27 February 2014

Our Ref: 140227PDASSDA5

Darling Harbour Live – The Haymarket Stage 2 State Significant Development Application (SSDA 5) – Hyder Consulting response to City of Sydney recommendations, Transport for NSW letter and the Department of Planning and Infrastructure comments.

**HAY STREET  
SHARED ZONE PLAN**

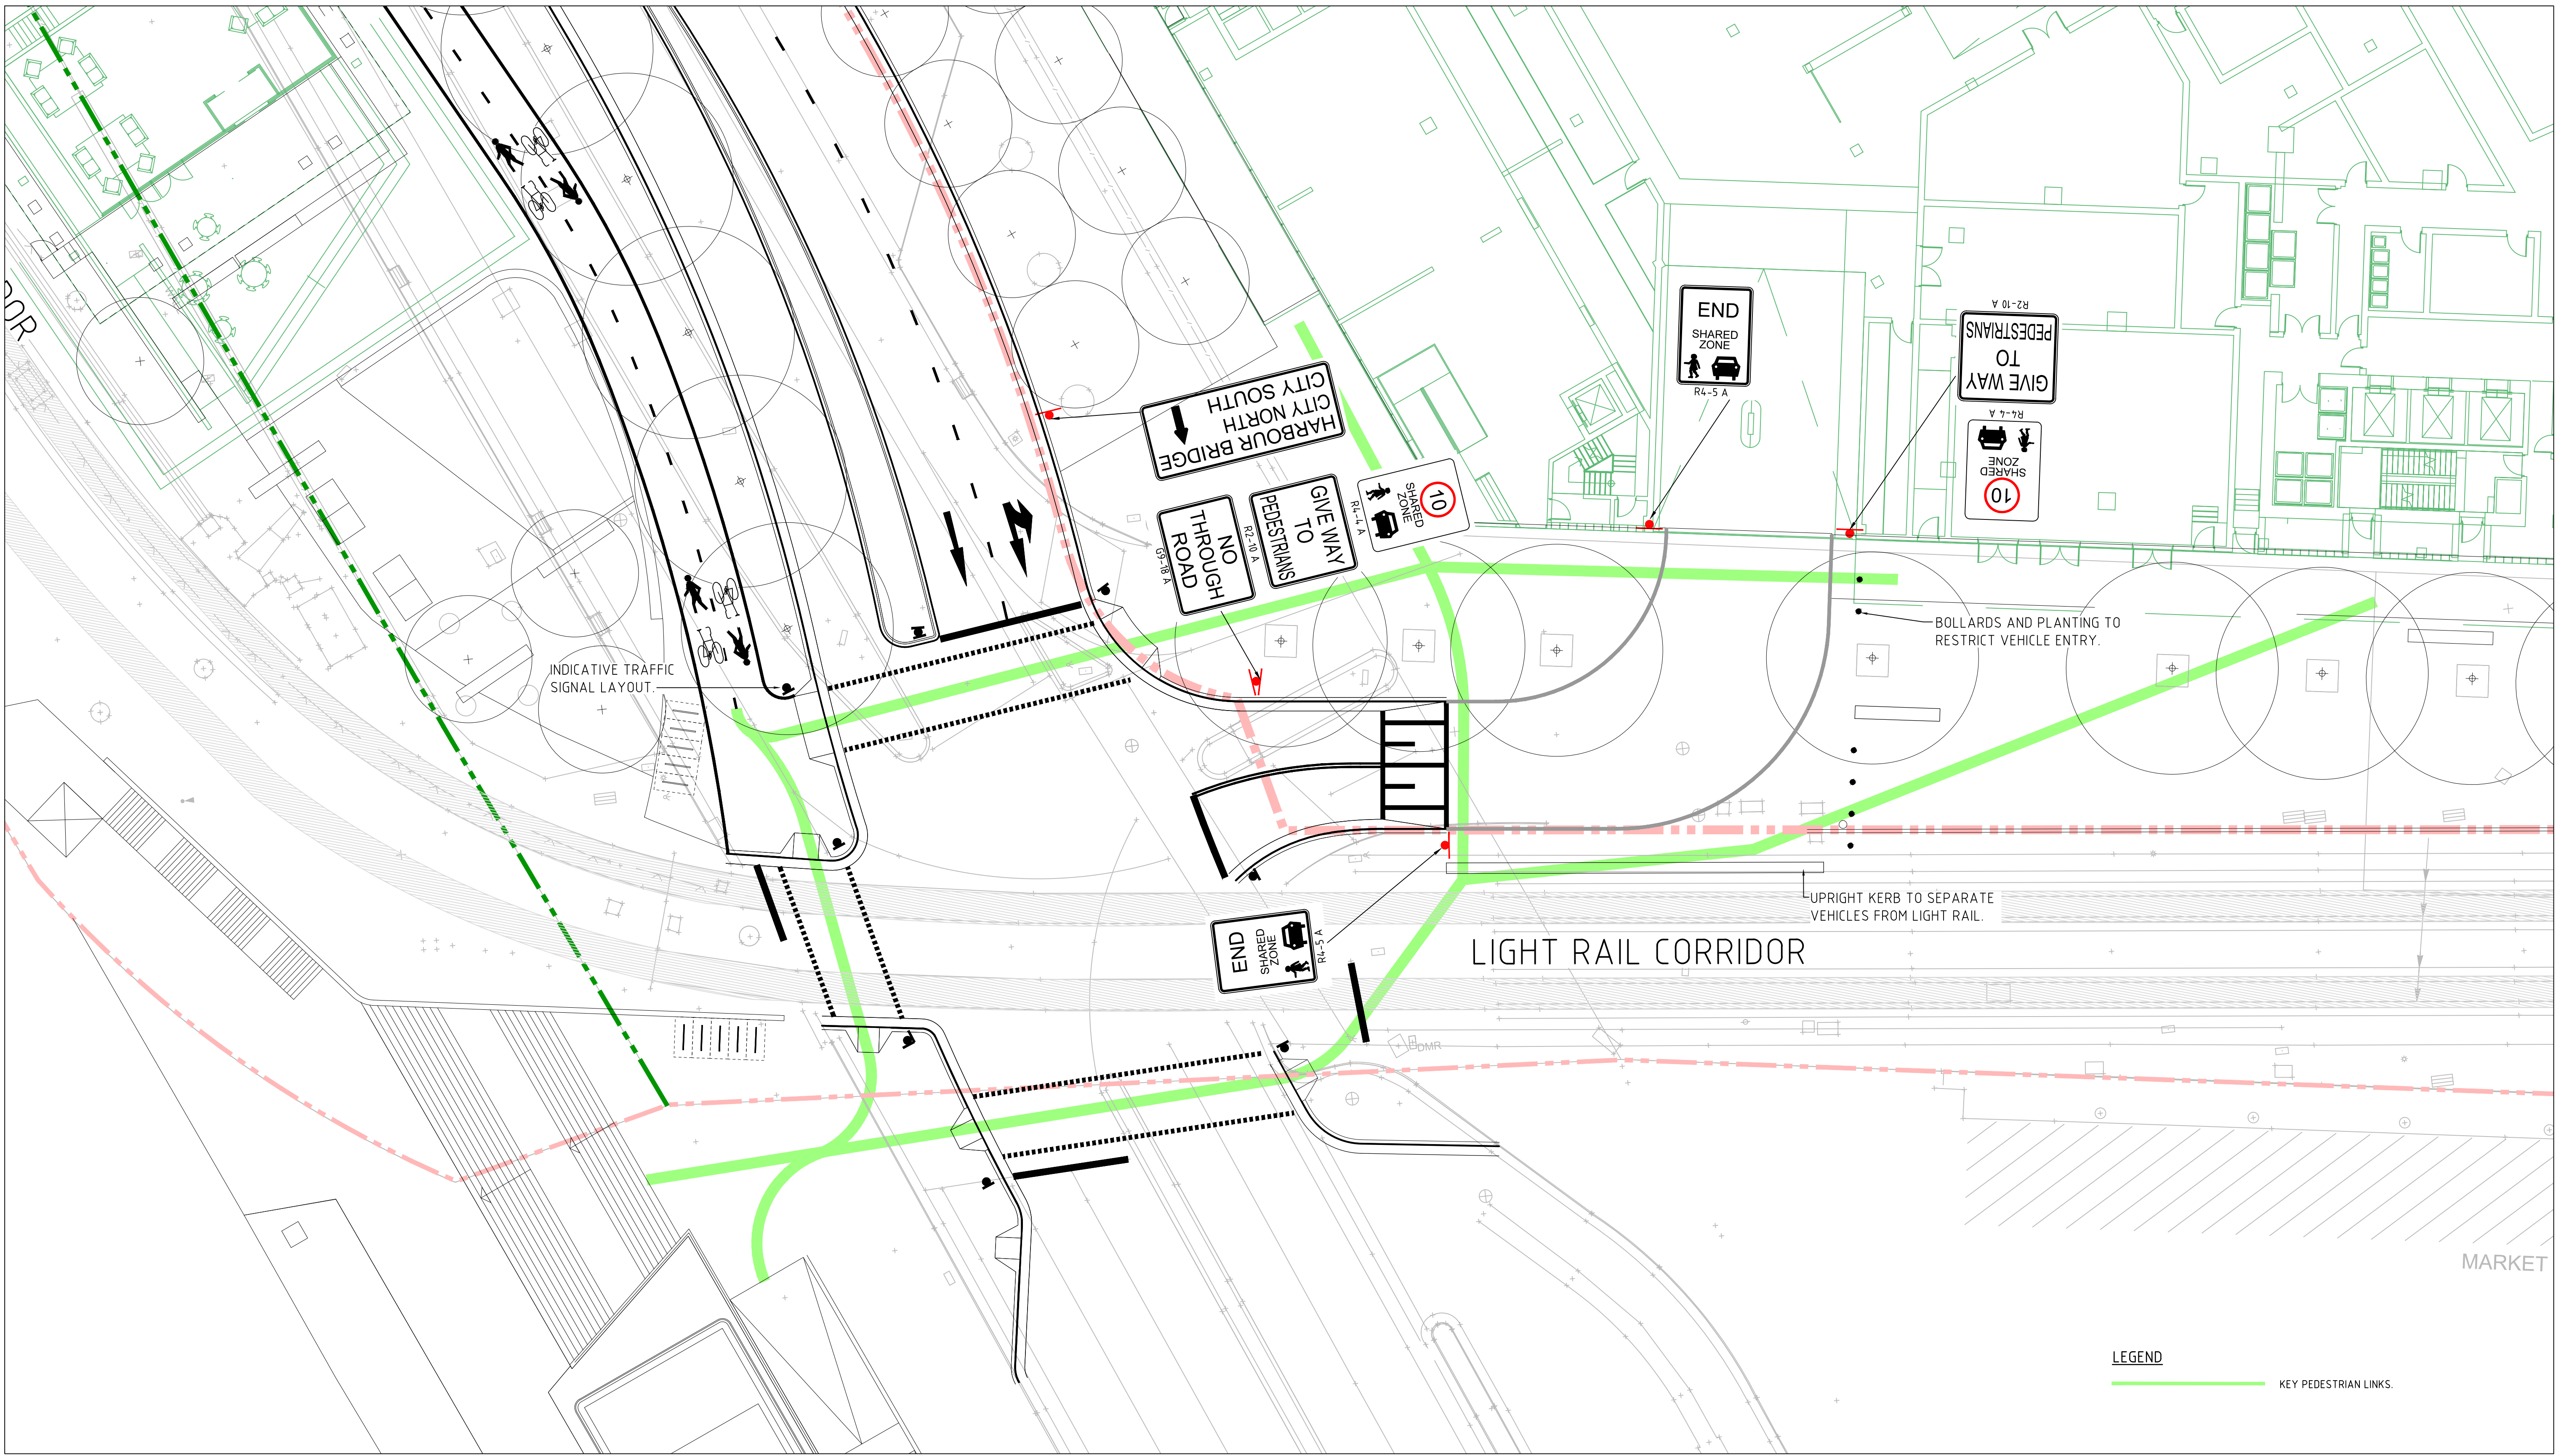
City of Sydney Council Issue	Hyder Response
Recommendation 8: There are a number of concerns about the design and layout of the lane and intersection associated with this driveway/lane/shared zone. It is recommended the Proponents work with the City to address these concerns. These issues include but are not limited to the following: - Whether the location can be relocated to Darling Drive - Ensuring the correct materials are used - Whether the lane is suitable for a shared zone arrangement - Pedestrian and cyclist accessibility - Necessity of a turning area, or alternatives to discourage vehicles from entering.	As noted above, the relocation of the vehicle entry to Darling Drive is not supported due to weaving and conflicting traffic movements from the Pier Street roundabout and the loop road along this part of Darling Drive along with the added complication of coordination with the signalised mid-block pedestrian crossing. The preferred option for this Hay Street access handle utilises a shared zone east of the intersection with Darling Drive (refer to appended Drawing SKCPD095) and has evolved to emphasise the pedestrian dominance of Hay Street whilst facilitating vehicular access to the SW plot. The design has also focussed on preventing inadvertent vehicular entry into Hay Street through the use of signage, varying pavement material types and landscape treatments. The resultant shared zone recognises the key east/west pedestrian link at the southern extent of the Darling Harbour Live Southern Precinct. Importantly, we confirm that the function of this space has been designed with due consideration given to the safety of pedestrians as a key priority. A clear delineation of function and space defined by specific landscape elements will ensure a safe interface between pedestrians and vehicles. In addition, this area will be clearly defined as a shared zone through the continuation of public realm materials, a consistency of levels, street signage, bollards, pavement types / colours and other landscape elements. Refer to appended Drawing SKCPD095 for the SW Plot access design and the resolution of Hay Street. Also refer to the Hassell Supplementary Public Domain Design Report for SSDA5.

Department of Planning and Infrastructure	Hyder Response
Traffic and Transportation 3. Clarification that the Hay Street driveway and crossover are appropriately designed and would encourage a safe pedestrian environment is required.	Refer to the previous detailed response for an explanation supporting the preferred resolution for Hay Street. Hyder confirms the proposed design solution for Hay Street has been resolved with safety as a key factor.

PROJECT NUMBER	DRAWING NUMBER	REV
AA004399	SKCPD095	07

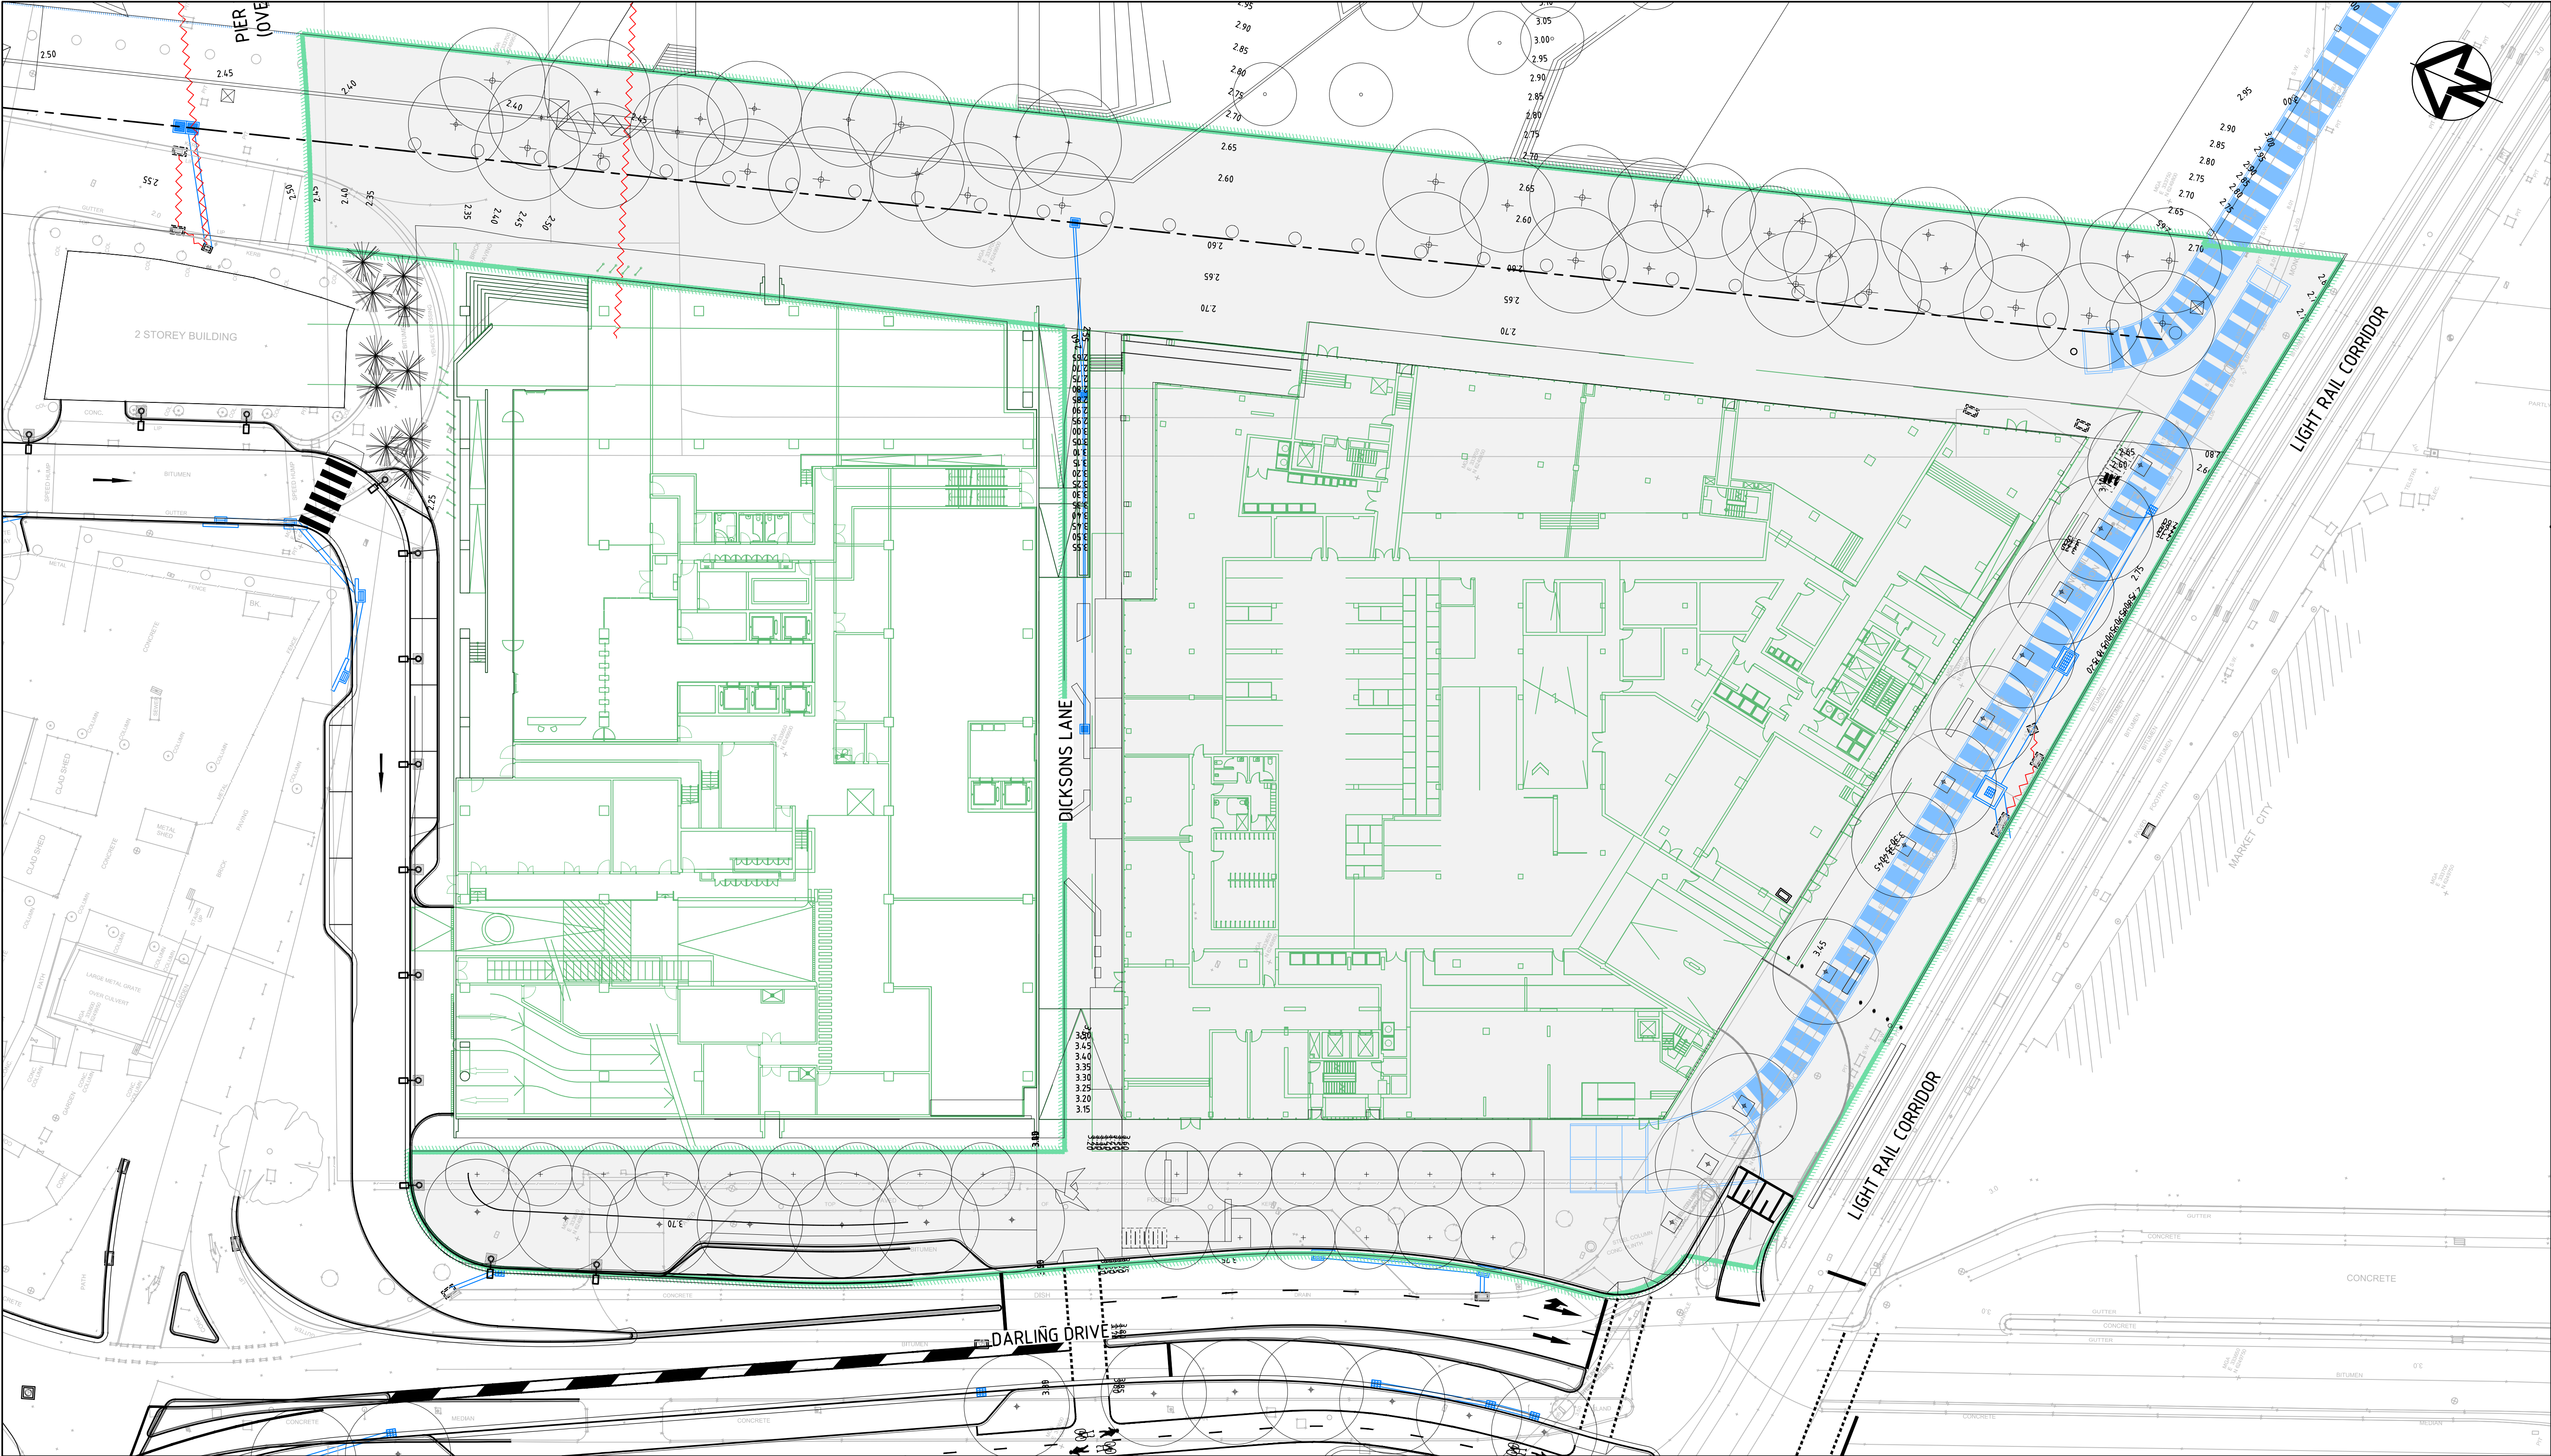
Department of Planning and Infrastructure	Hyder Response
6. Clarification is required of the proposed pedestrian connections west to Ultimo and east to the CBD.	West to Ultimo, within the Southern Precinct, the key proposed pedestrian connections are illustrated in Figure 1 and include: - A connection between The Goods Line and Darling Drive via the Macarthur Street walkway connection. This access is provided via the lift and stair integrated into the existing elevated Macarthur Street walkway, which then utilises The Goods Line to connect to Darling Drive via a ramp and stair (the subject of a separate application known as The Goods Line); - The pedestrian crossing across Darling Drive will be maintained at the signalised Hay St/ Darling Drive intersection; and - The new signalised pedestrian crossing facility on Darling Drive under SSDA3 providing a pedestrian linkage from the west of Darling Drive through to the Boulevard via Hay Street and Dicksons Lane. Pedestrian connections to the CBD on the east will be maintained via the existing Hay Street and Golbourn Street pedestrian linkages. Further north of SSDA5, pedestrian connections to the CBD are provided via the Boulevard to Tumbalong Park then onwards to the east via the existing pedestrian walkways to/from the CBD (Refer to attached Figures 1 and 2)
